Building Inspections - Re:

From: "Michael Doherty" <mike@shedhappens.com>
To: "Building Inspections" <buildinginspections@portlandmaine.gov>
Date: 6/18/2014 11:04 AM
Subject: Re:

The sign will be placed in the the South East corner of the property as drawn on the diagram, 5' from front and side property lines.

Michael
the plot plan is a little deficient in the requirements. This is from the checklist of requirements:

**Amended Site Plan**  
On  
Warren Avenue & Grove Street  
In  
Portland, Maine  
For  
**Shed Happens, Inc.**  
C/O Michael Doherty ~ 711 B Roosevelt Tr. ~ Windham, ME 04062

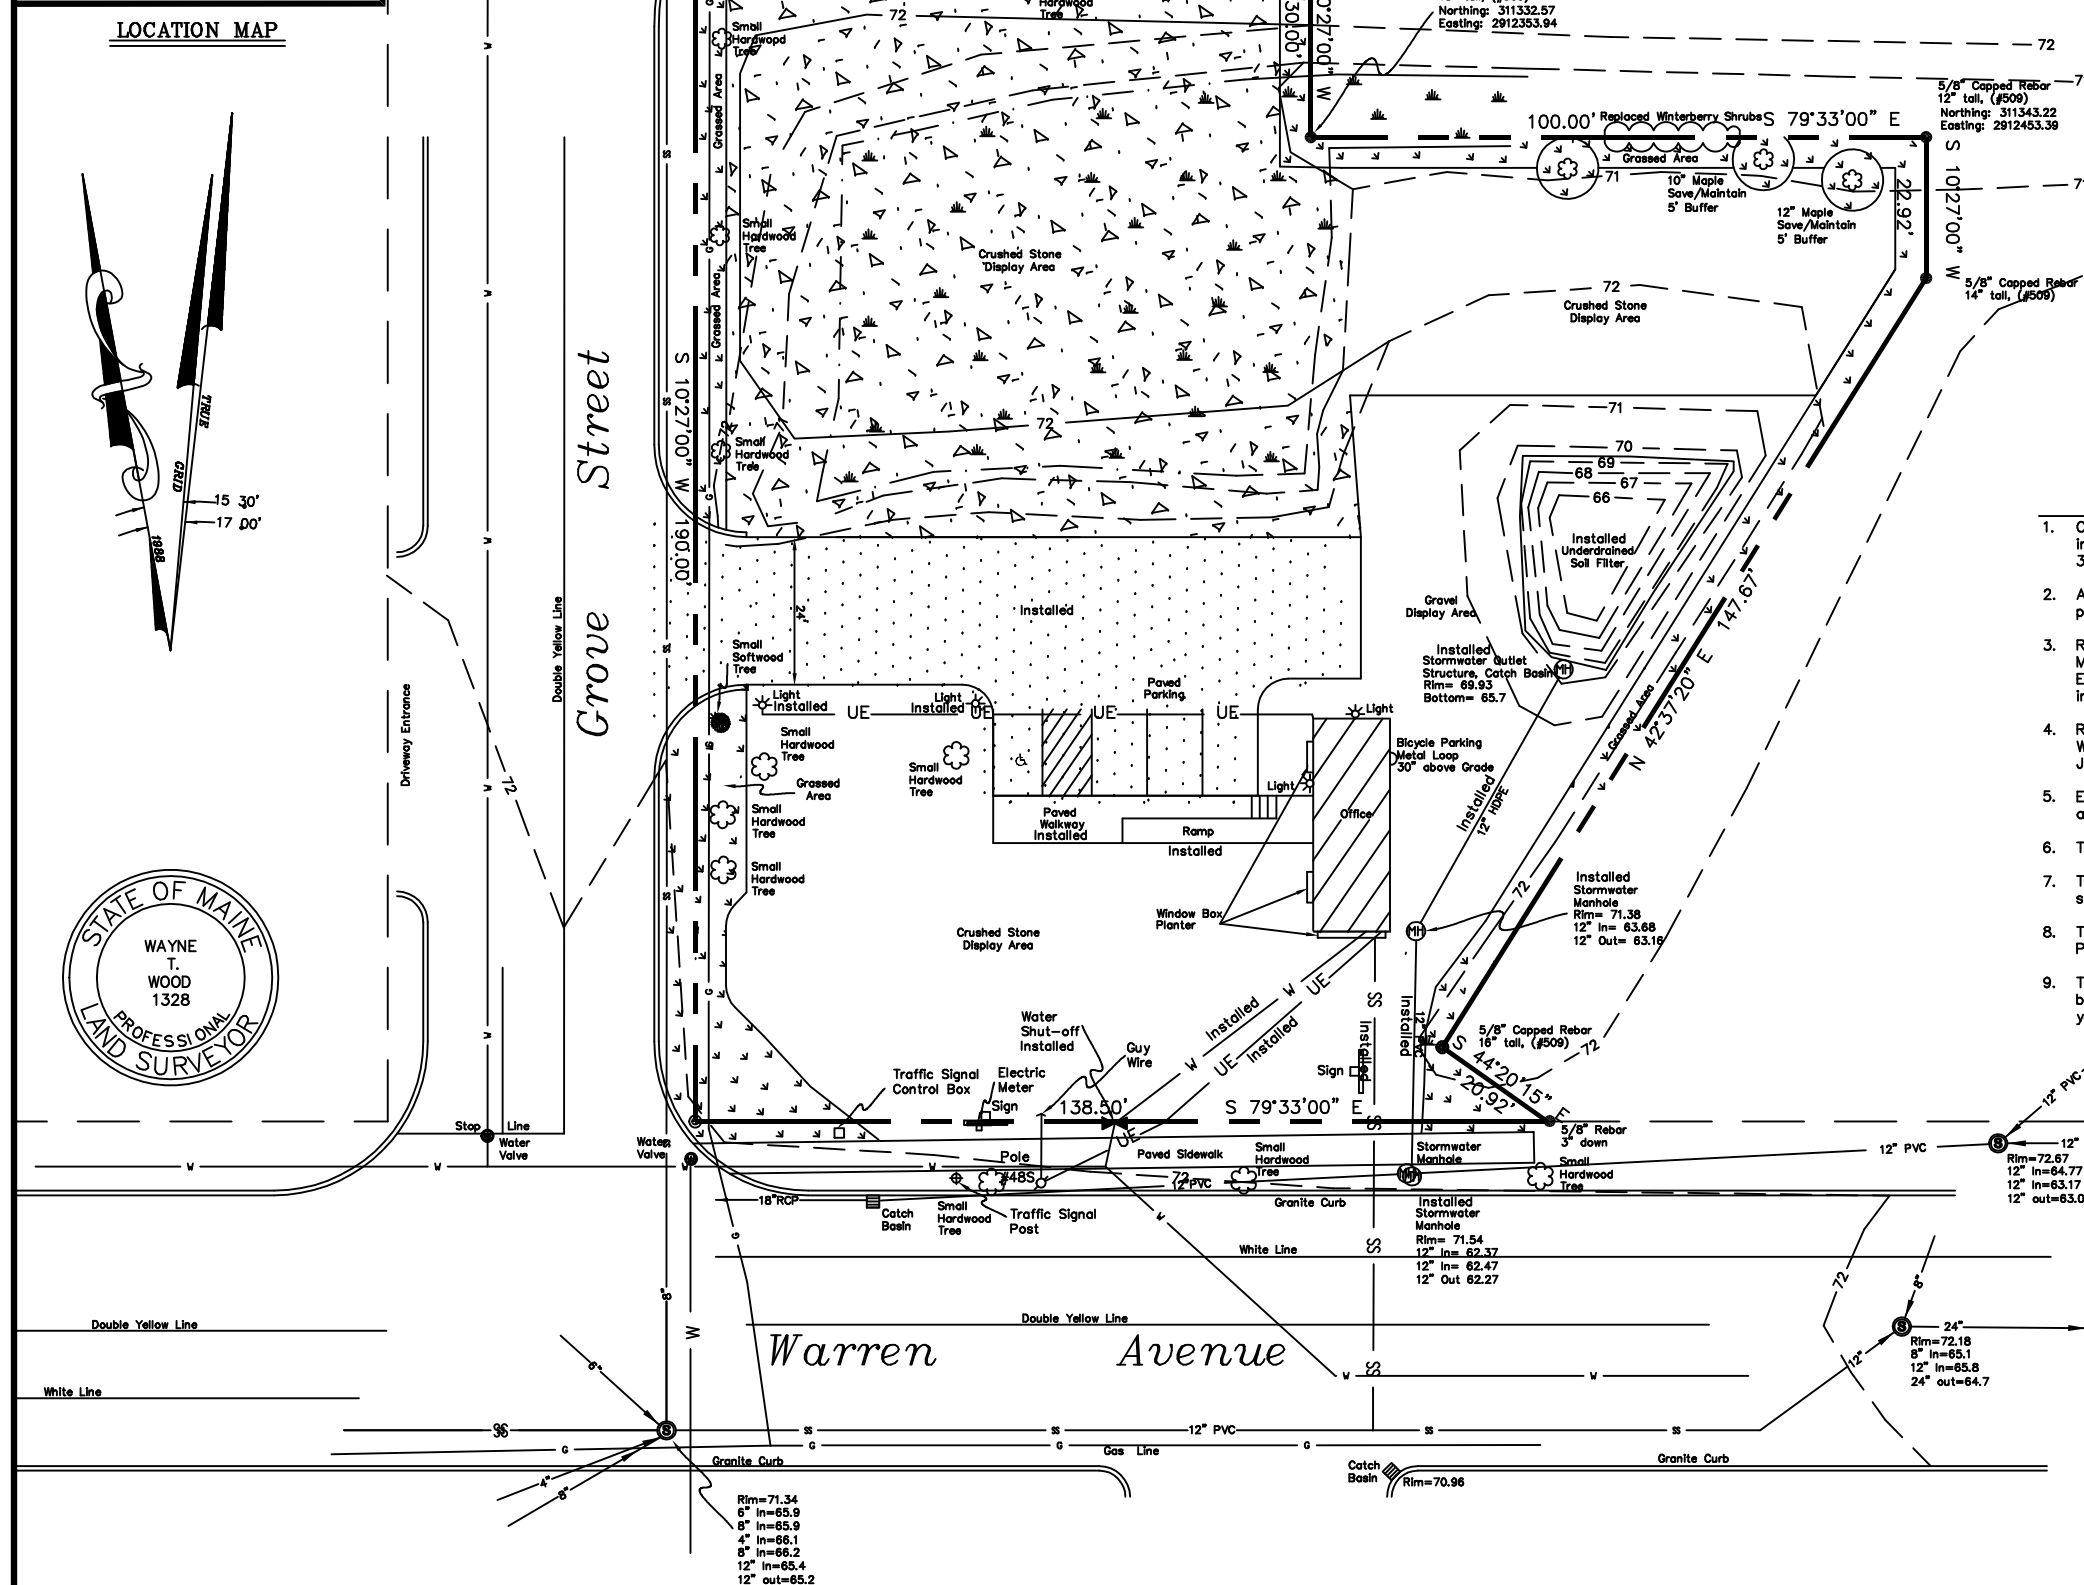
A sketch plan of the lot indicating location of buildings, driveways, any abutting streets or rights of way, lengths of building frontages, street frontages and all existing setbacks. Please indicate, on the plan, all existing and proposed signage with their dimensions and specific locations.
